Application for a Non-Material Amendment Following a Grant of Planning Permission

Two storey side extension, loft conversion and internal alterations

2023/1637/HSE

Omission of the use of Natural Stone from the principle elevation, and its substitution with an alternate material as specified on the latest revision of the planning drawings.

ENSUITE: BEDROOM 5
 [SCALE 1:50]
 LIMITED HEAD HEIGHTS - FOR CLIENT APPROVAL

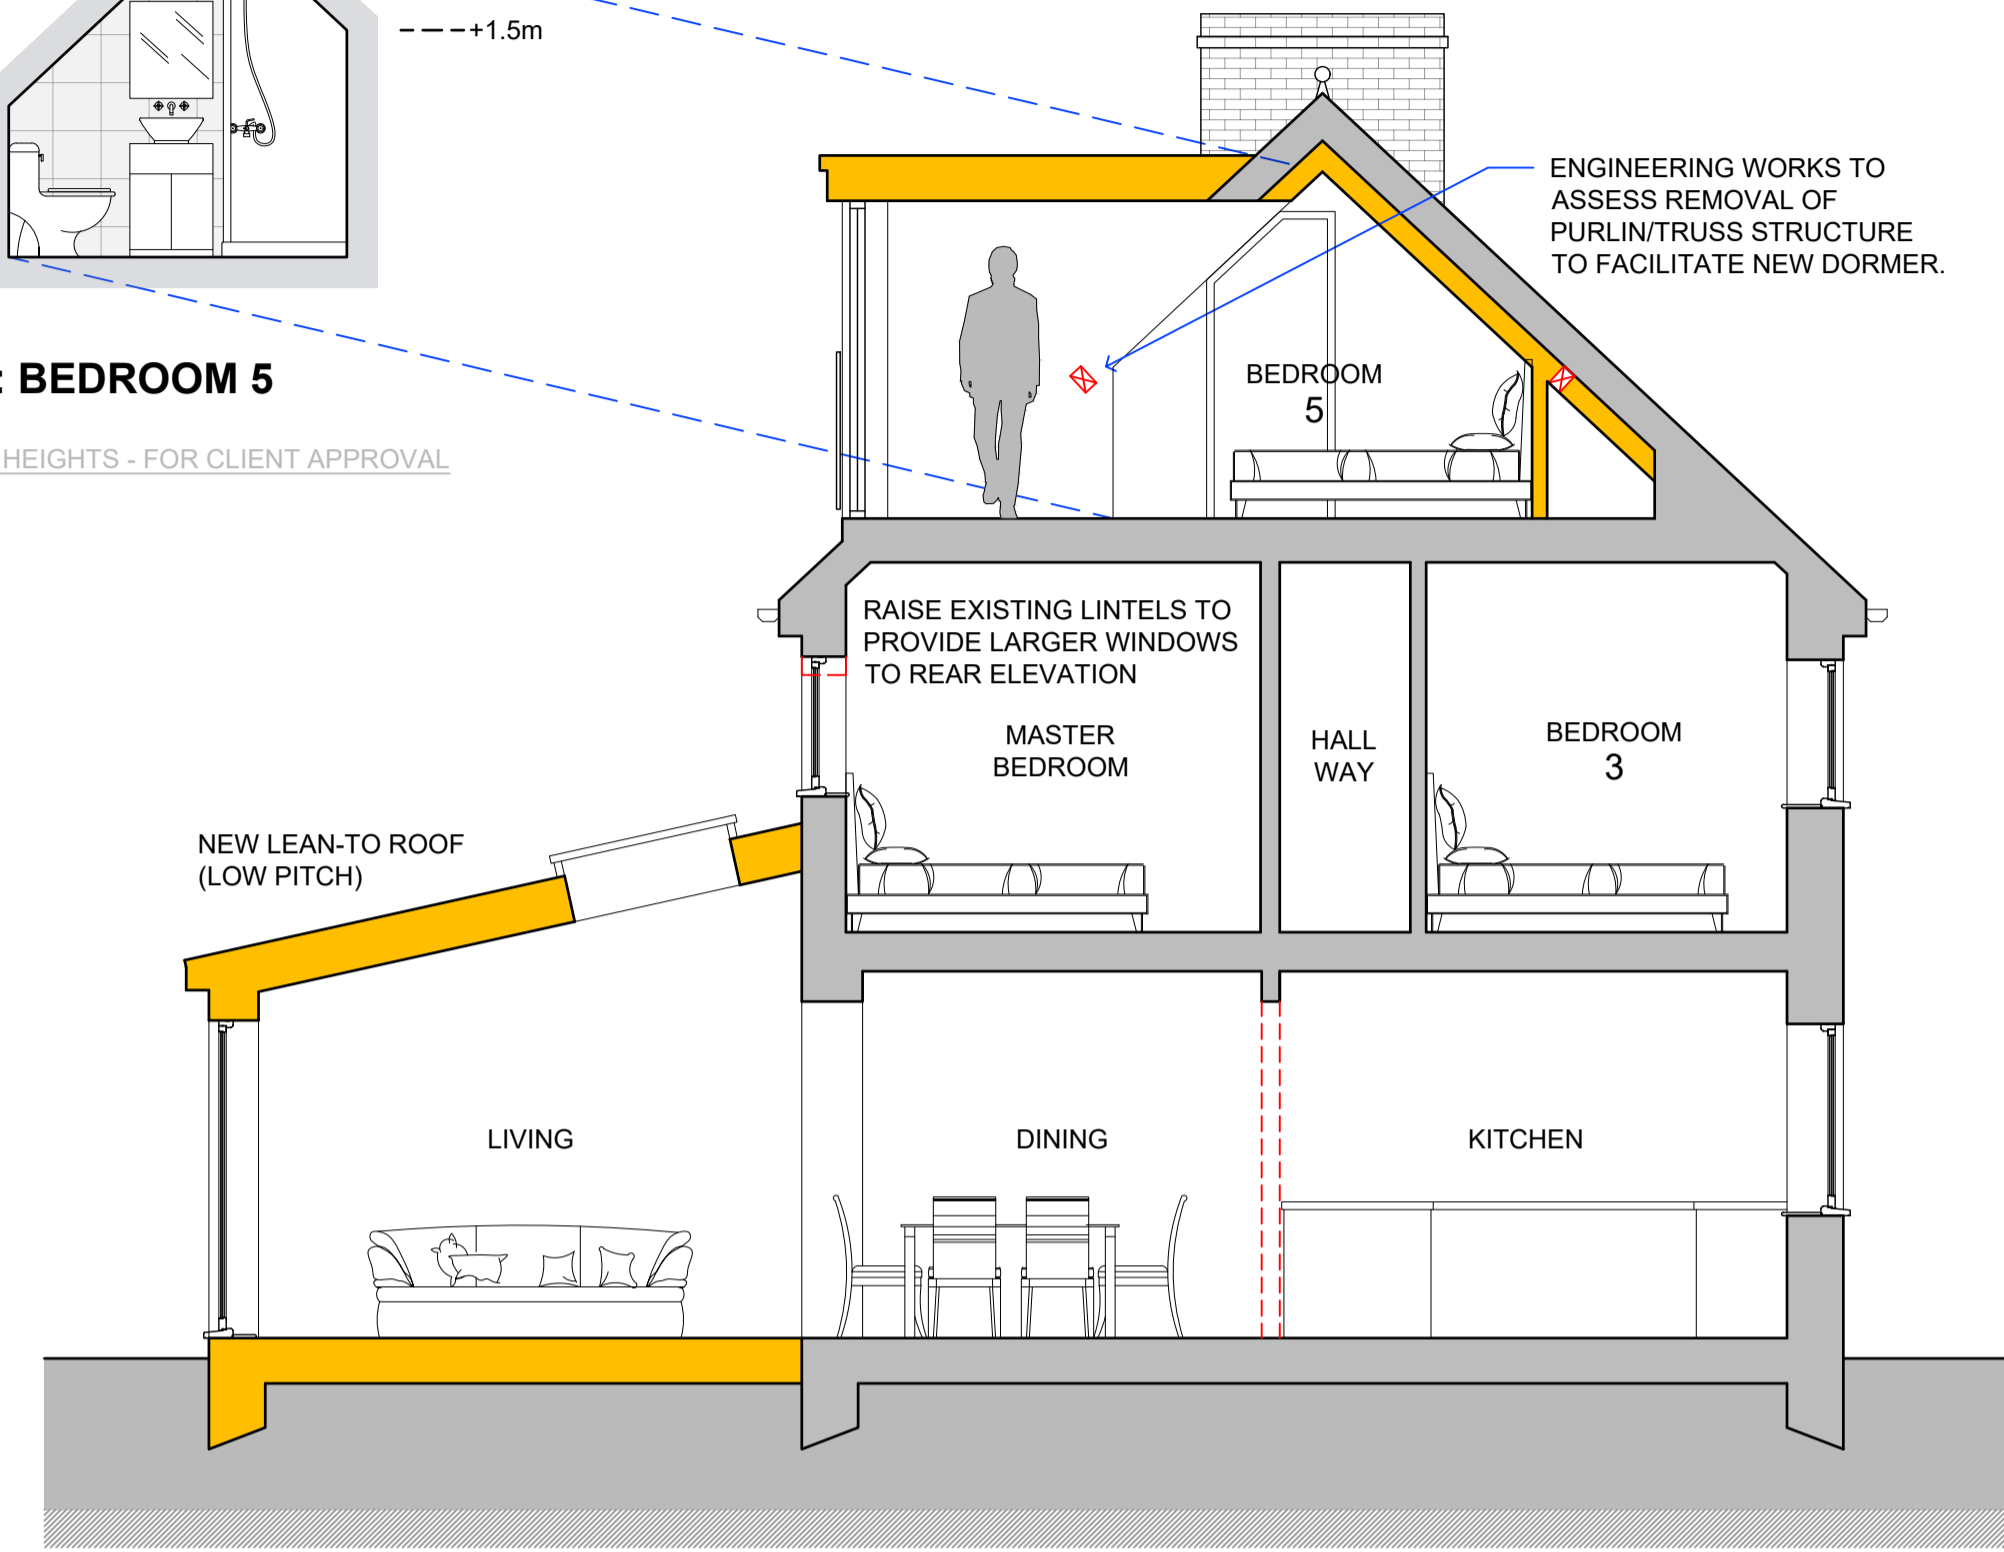
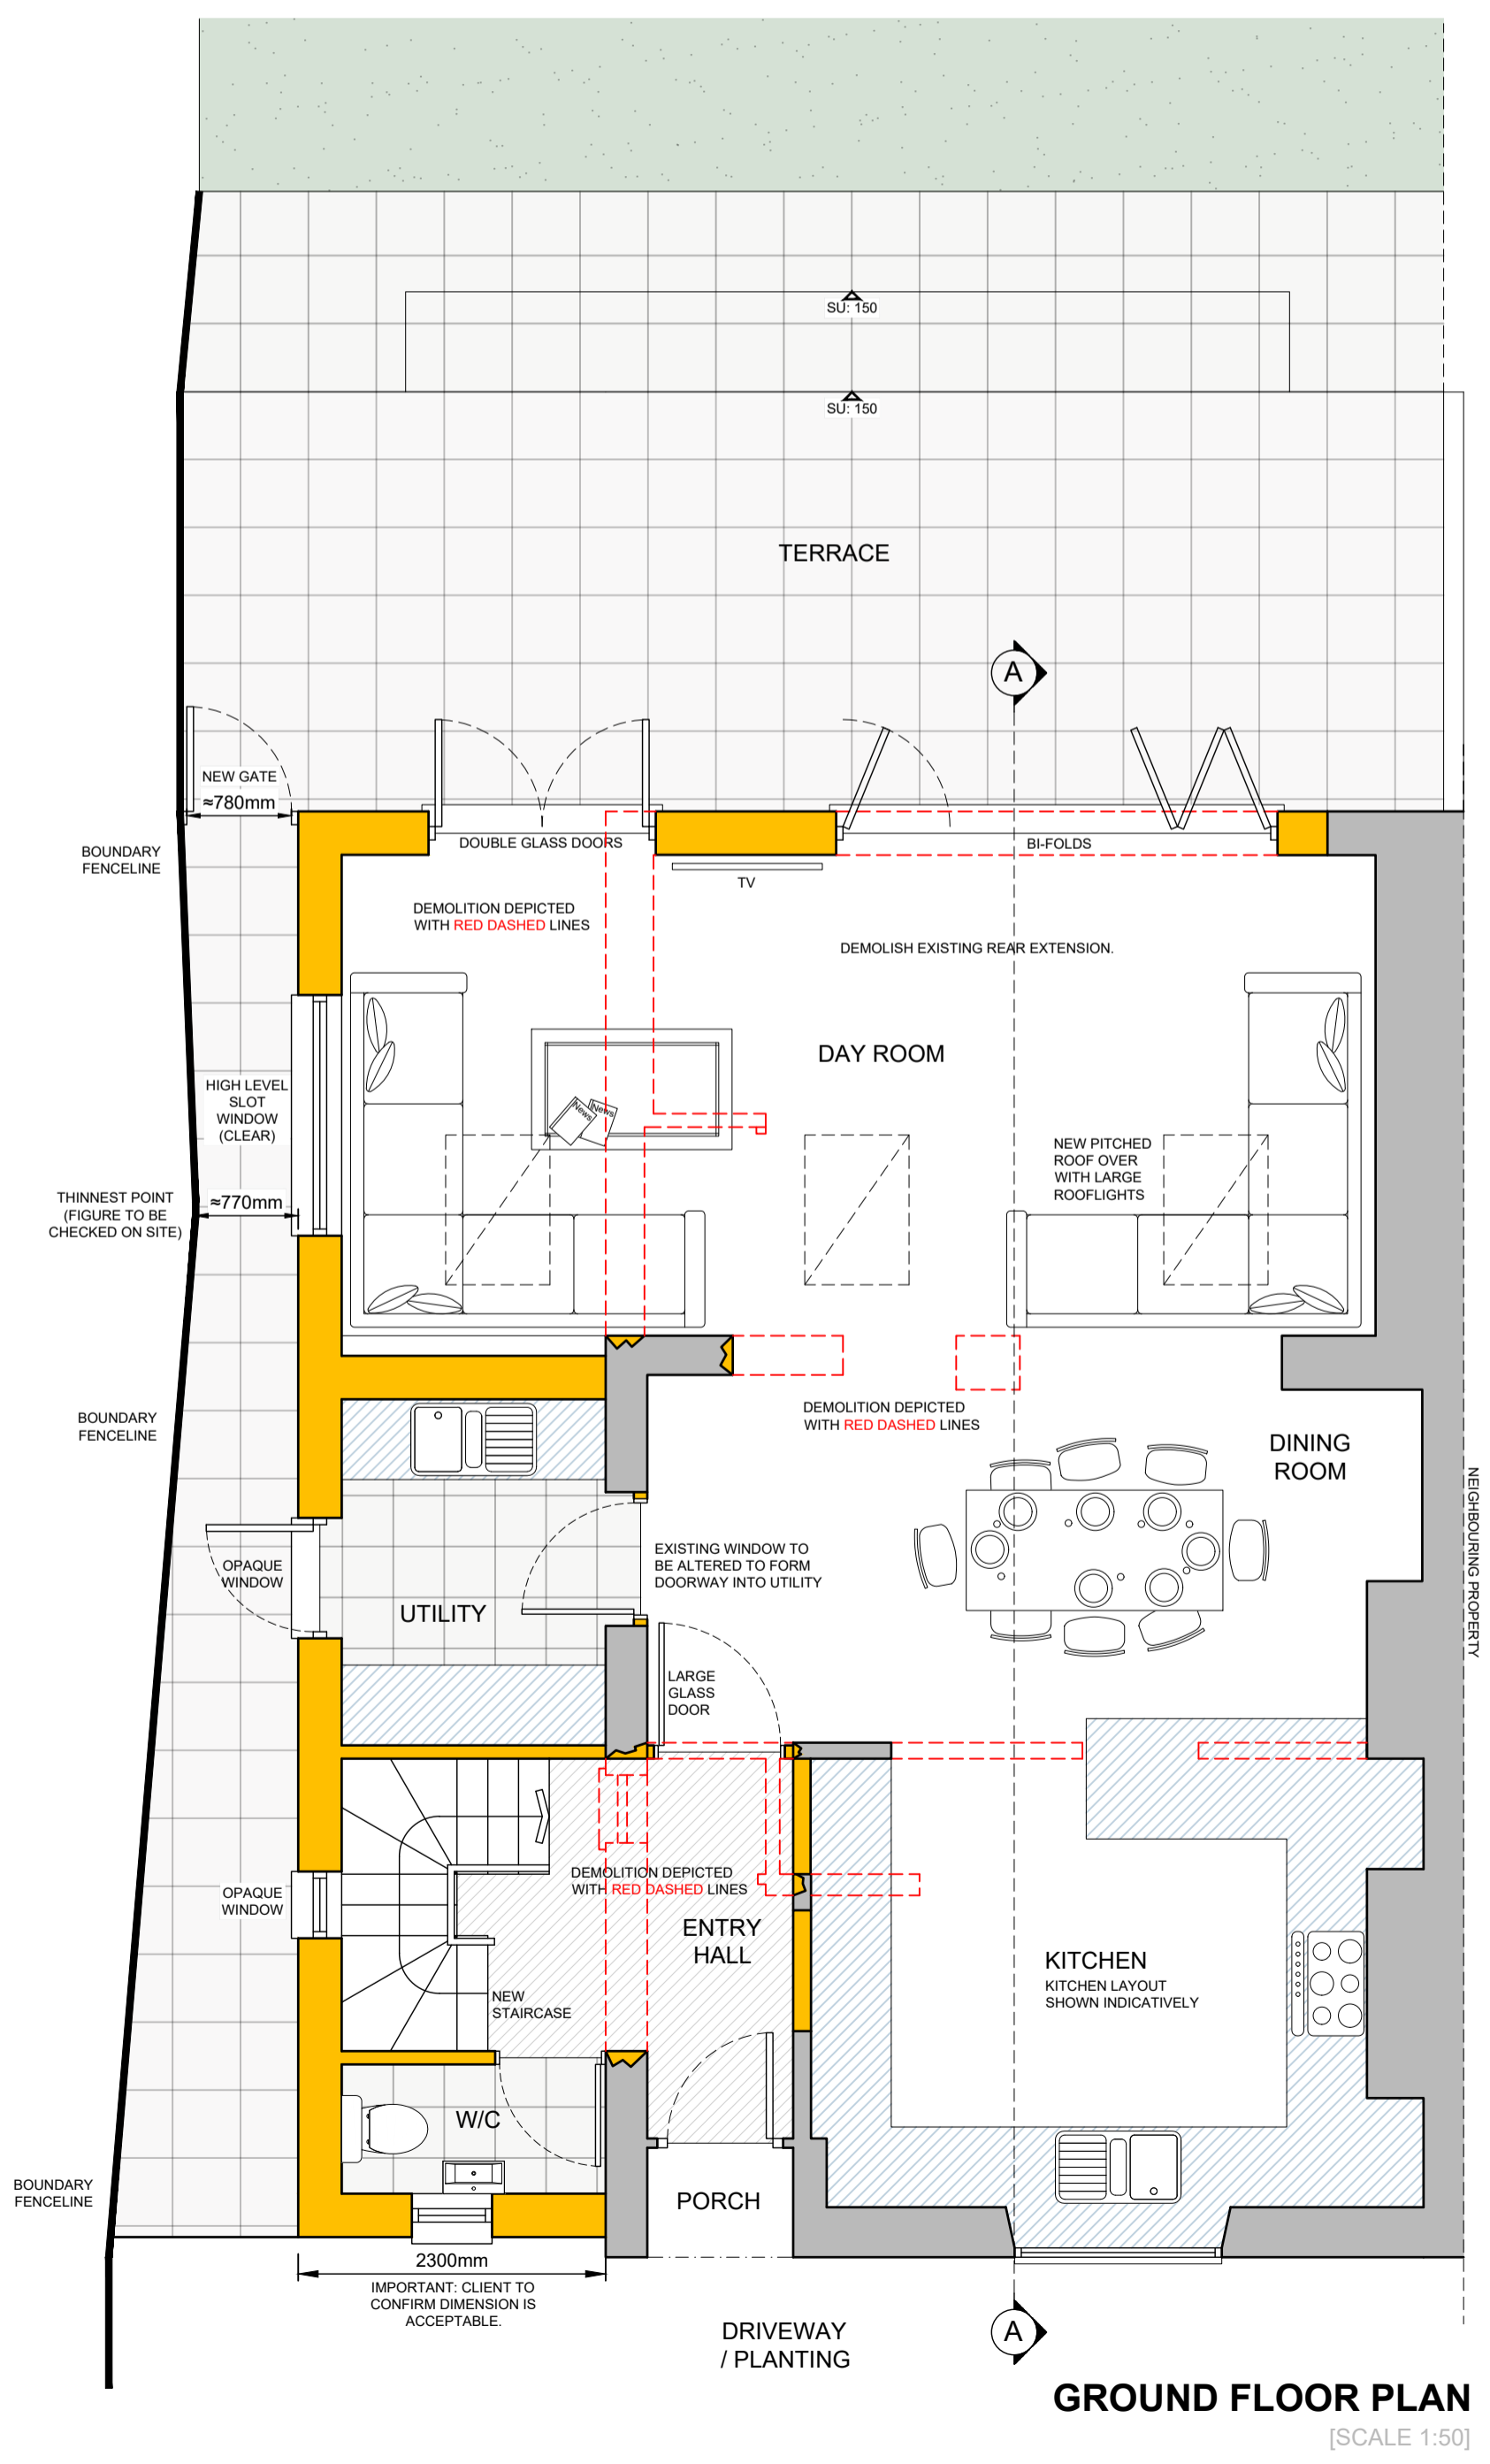
Due to difficulties with sourcing matching, now unavailable historically sourced stone, and due to mitigate overall build cost to excessively high costs to undertake the works with natural stone.
